## DECISION DELEGATED TO DEVELOPMENT MANAGER

**Application No:** H16-0259-20      **Applicant:** St John the Baptist C of E Primary School

**Proposal:** Extending and re-surfacing of school car park, new drainage and new entrance and exit barriers.

**Location:** St John Baptist Va Primary School Hawthorn Bank Spalding

New Main Gate & Gate Posts Elevation
Scale 1:20

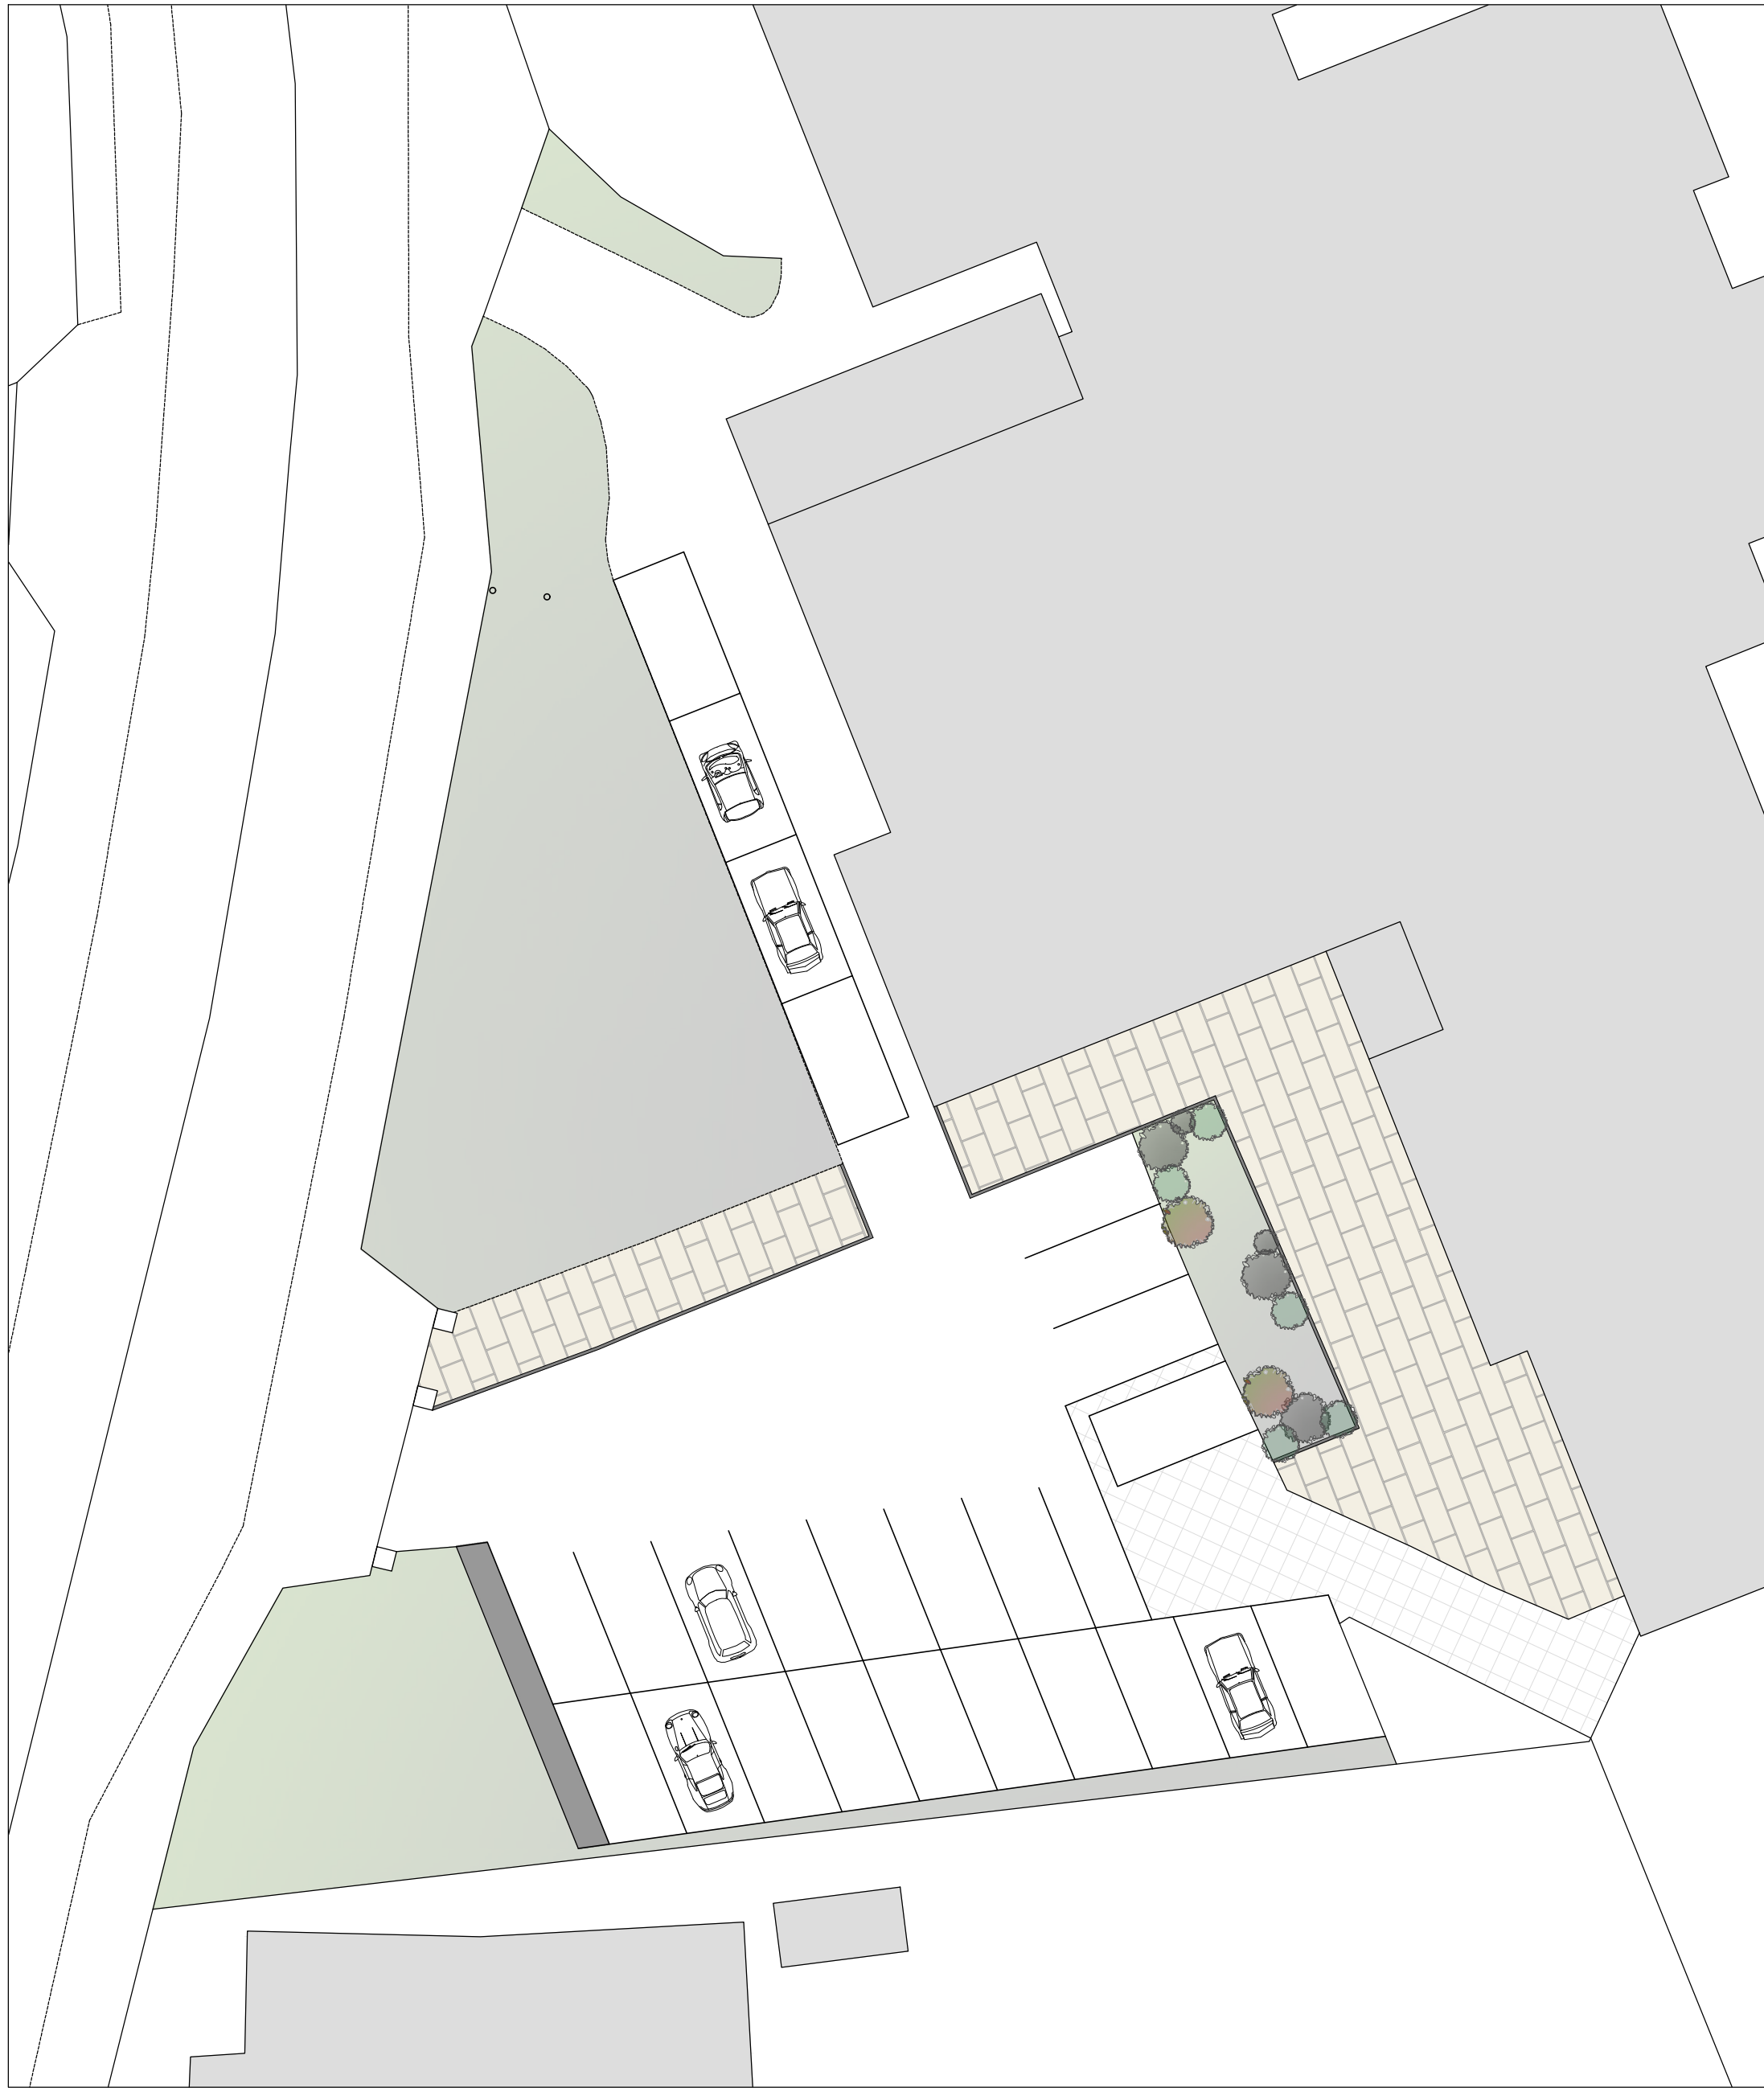
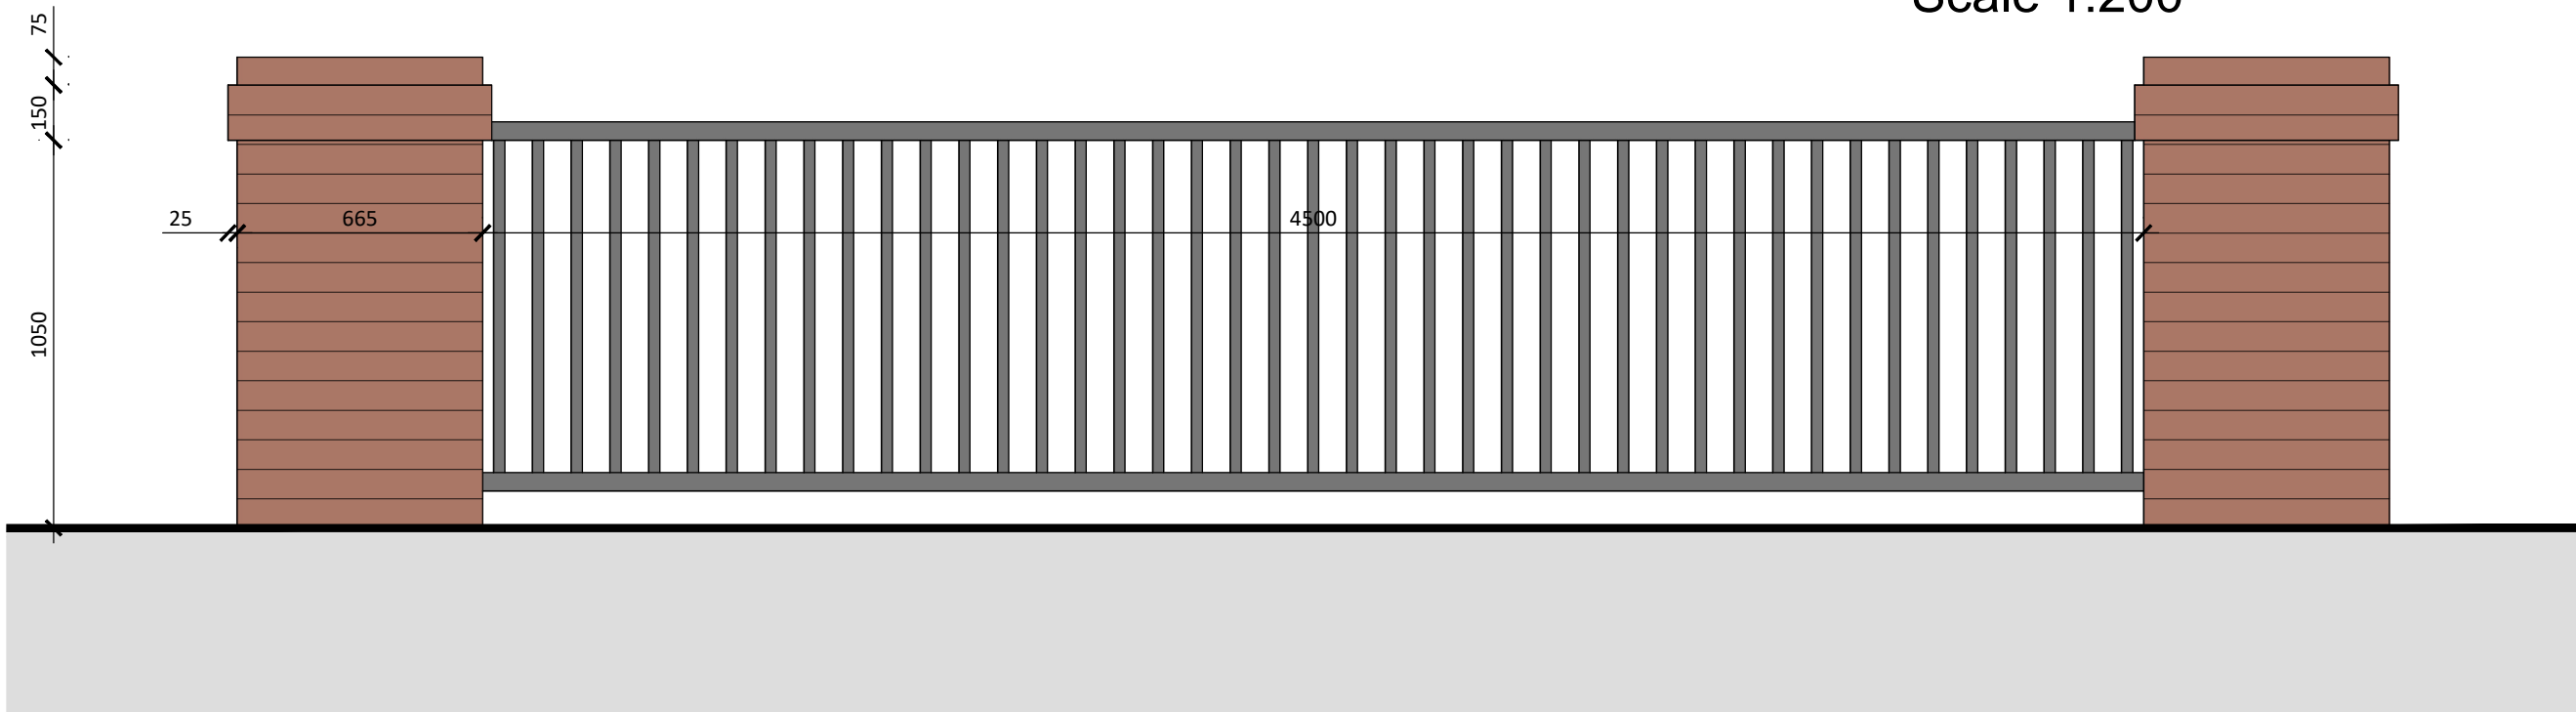
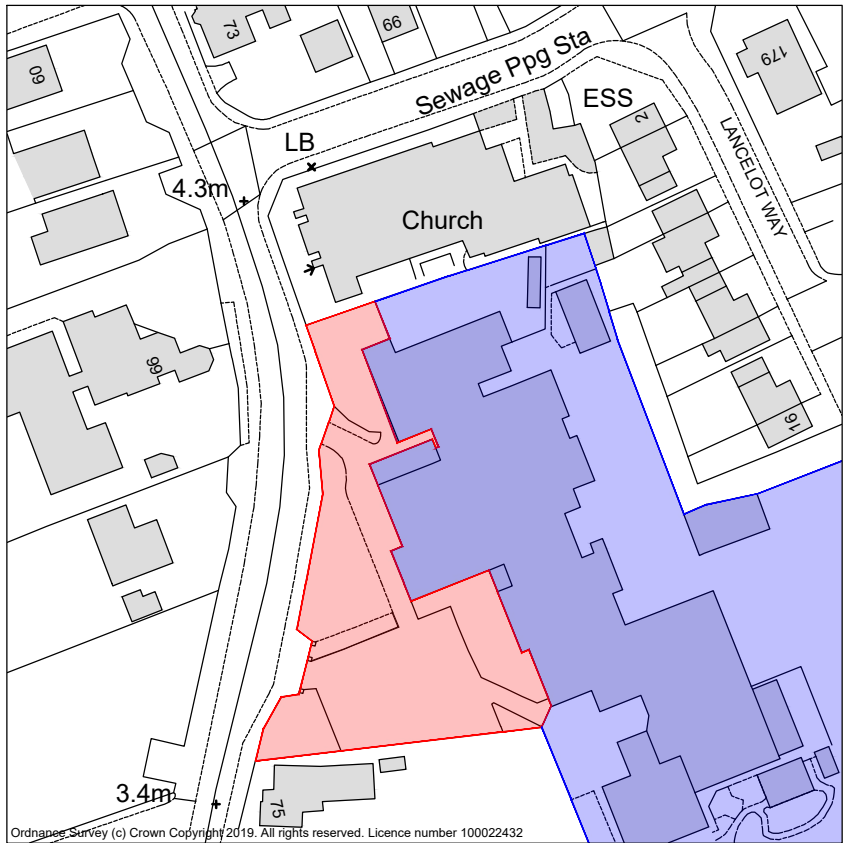
No objections but would advise the applicant that any gate should be a minimum of 5m from the nearside edge of the carriageway and will not open out onto the highway.

The Local Highways authority have raised no objection to this proposal but do ask that the proposed entrance gate be set back 5m from the nearside of the carriageway (Kerb) and that the gate would not open outward towards the highway. It is proposed that the gate would be a side-sliding gate and the exit gate would be a rising bar gate. The entrance gate appears to be set back further than 5m from the kerbside according to the measurement and scale of the drawings provided, furthermore, the included design and access statement does declare that the gate will be set back such that a vehicle could pull completely off the highway. However, as specific measurements on the distance from the kerbside are not given, it will be conditioned that the gate be set back 5m from the kerbside.
